From: Andrew Wood
Sent: 15 March 2019 16:19
To: Lynnyrd Wolfe
Subject: FW: Planning Application FG/220/18/PL : Land adjacent to Elm Lodge, Tamarisk Way, Ferring, West Sussex BN12 5ER
Attachments: Revised Site Plan 22.2.19.pdf; Land Registry Scan 1983.pdf; Documents emailed to Laura on 19.2.19.pdf

RE: Planning Application FG/220/18/PL : Land adjacent to Elm Lodge, Tamarisk Way, Ferring, West Sussex BN12 5ER

EXISTING POND ACCESS
PLAN

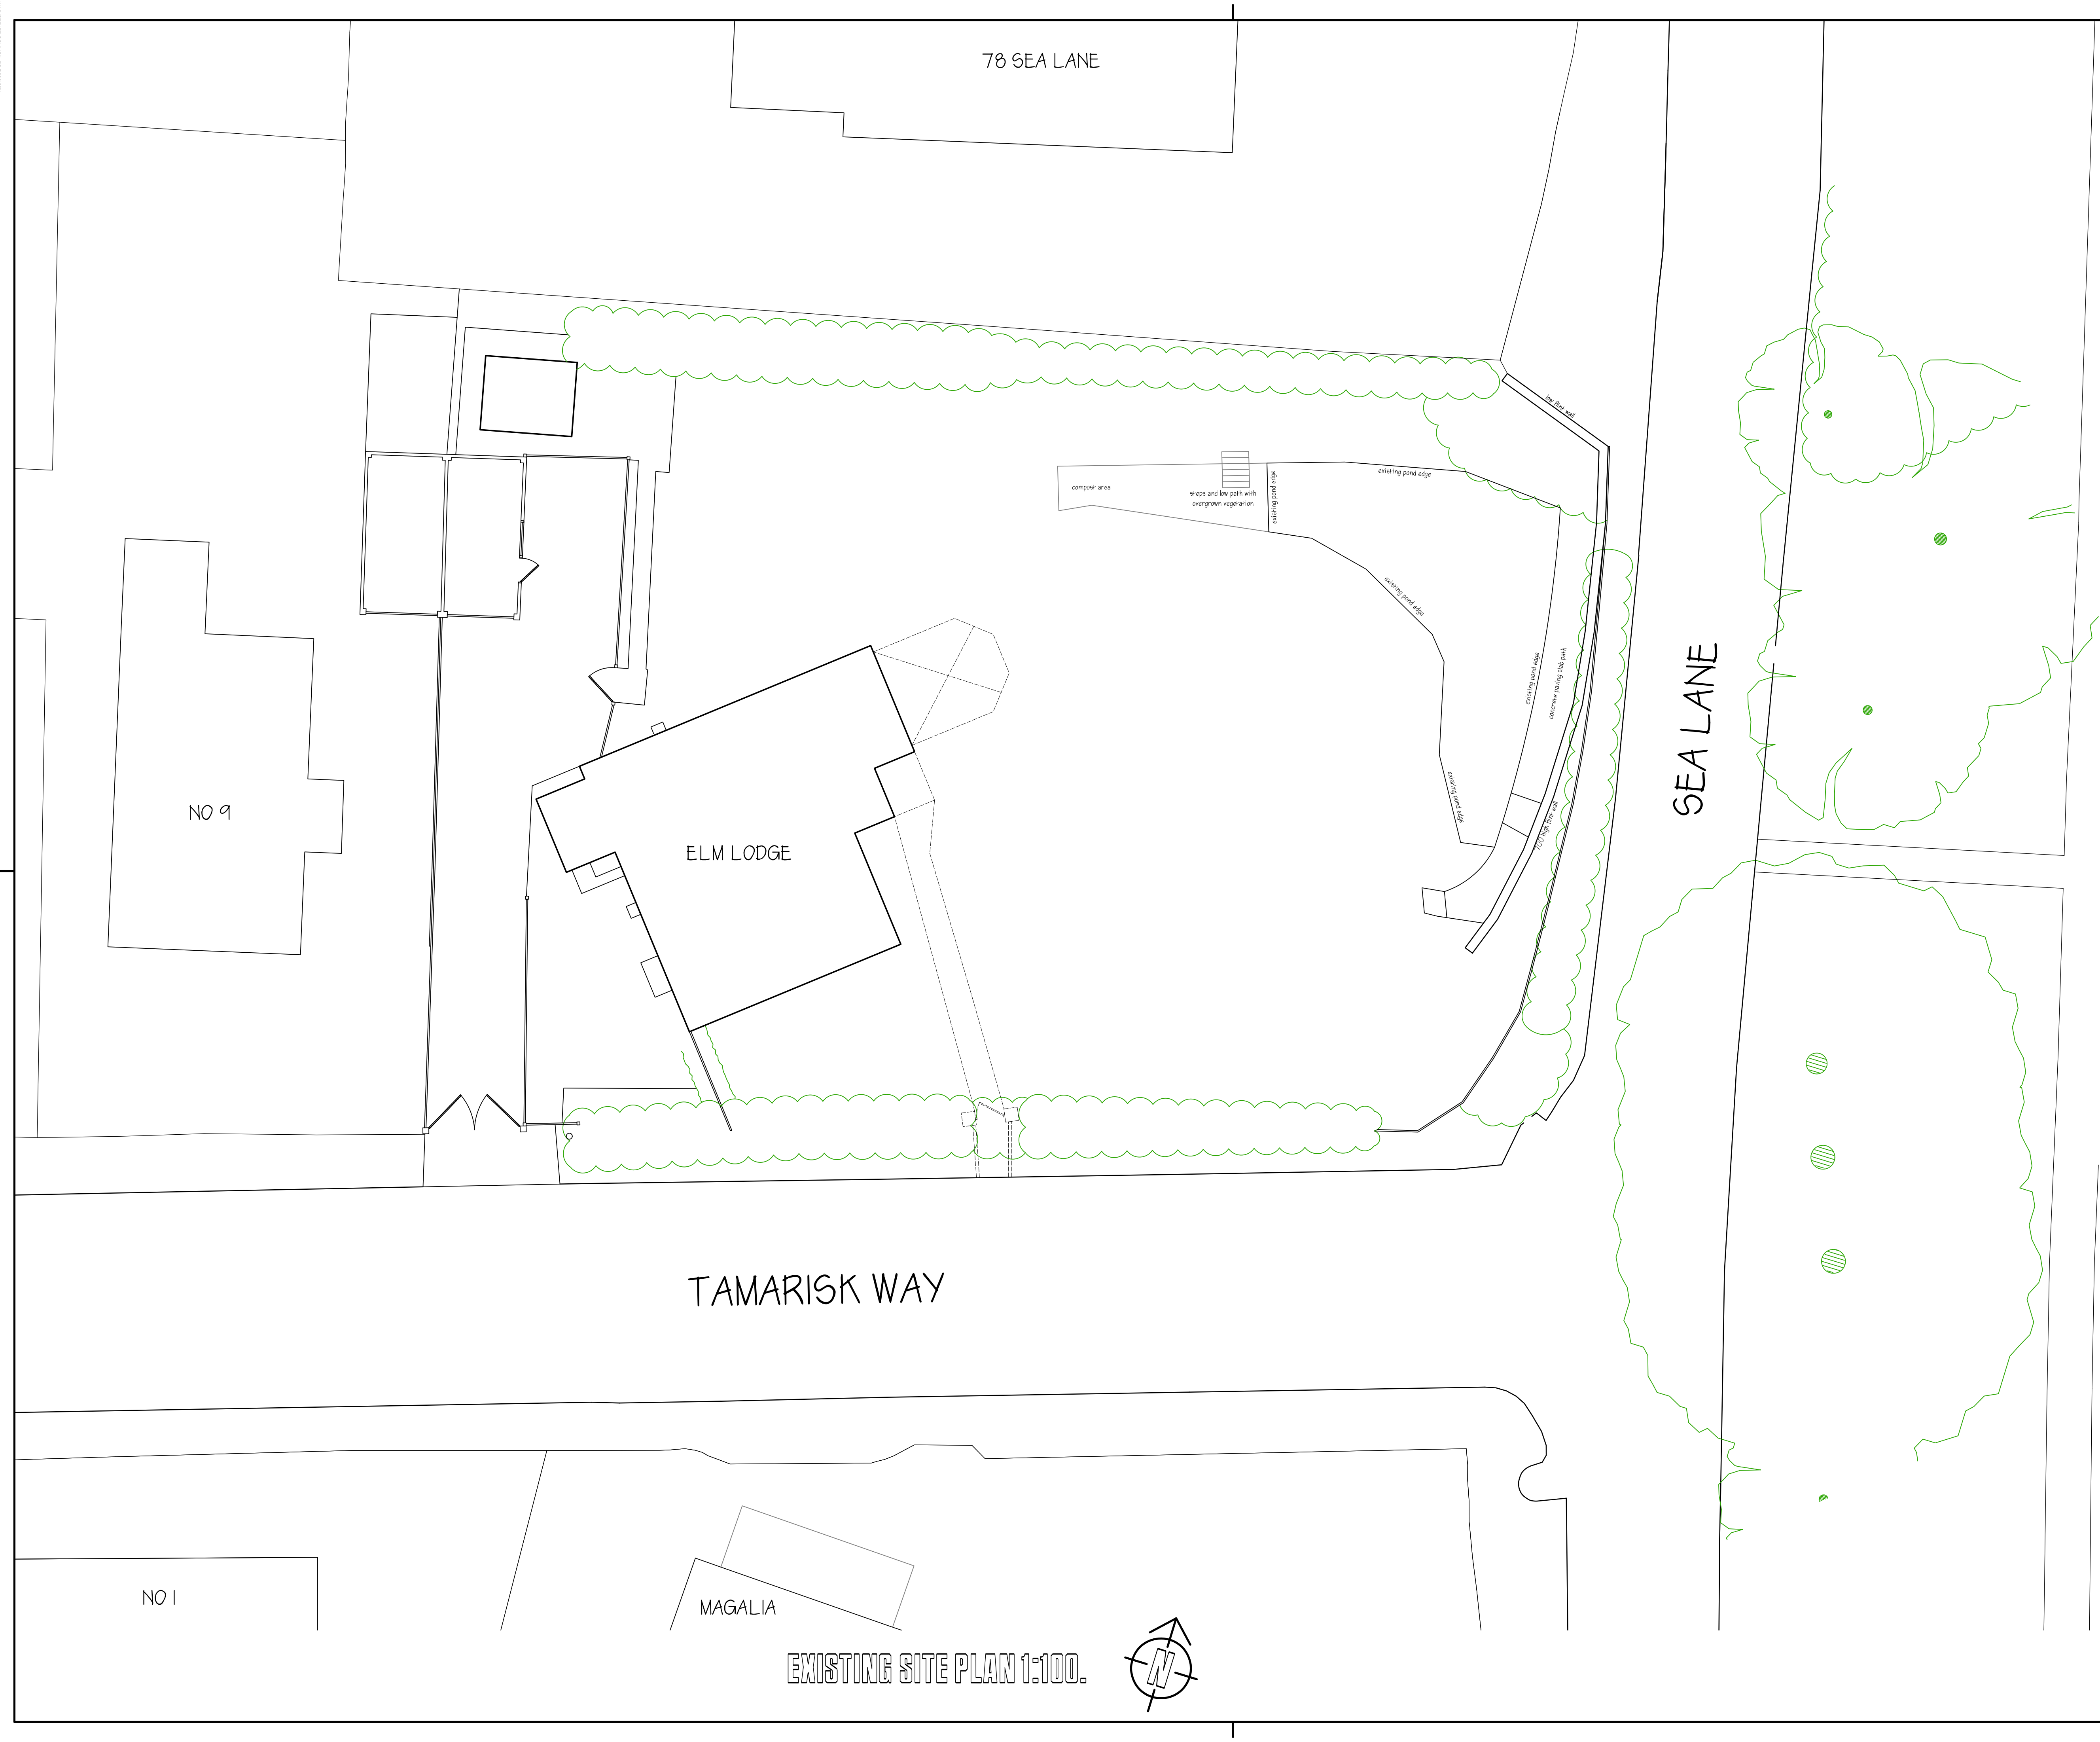
3. It is my belief that there is no way to get to the northern and western portions of the pond without tracking through the pond itself. This would mean that maintenance would have to be completed in the summer by the landowner when water levels are lower. This would then be within nesting bird season. I would much prefer an access to be provided around the pond. I note that you state the 1m wide path to the east could take plant but this plant would not be big enough. As explained above, we as landowners can continue to access the pond from all sides, with 3m to the West, North and South East. We cannot understand what plant would ever be required (given no plant has ever needed to access the pond before, and any plant necessary for carrying out works to the pond can have full access from all sides as part of the building works) that would ever be larger than a small digger, which can easily be maneuvered up the 1m side access to the west of site and around the rear. You are going to need a large digger to access the pond and clear it of vegetation and silt. The size of machine is dictated by the depths that excavation need to be carried out to, the size of plant that can fit along a 1m path would not be sufficient to carry out the excavation required. Ongoing maintenance will be required after construction is complete, this is when the proposed site layout in my opinion would prevent this work.

Further to our meeting at the land adjacent to Elm Lodge, Tamarisk Way, Ferring, West Sussex BN12 5ER on 12th February 2018, please find attached the existing and proposed pond access plans as requested. These show the existing pond to be retained in its entirety, with 3m access provided should Arun District Council ever need to access our property to maintain the pond. We hope these now alleviate your concerns regarding potential future access. We also note that the path to the east of the pond is also over 1m wide, which can currently comfortably accommodate a 1.5 ton digger to carry out any works. Given that there are multiple points of entry along the edge of the pond, any further work can be carried out from within the pond.
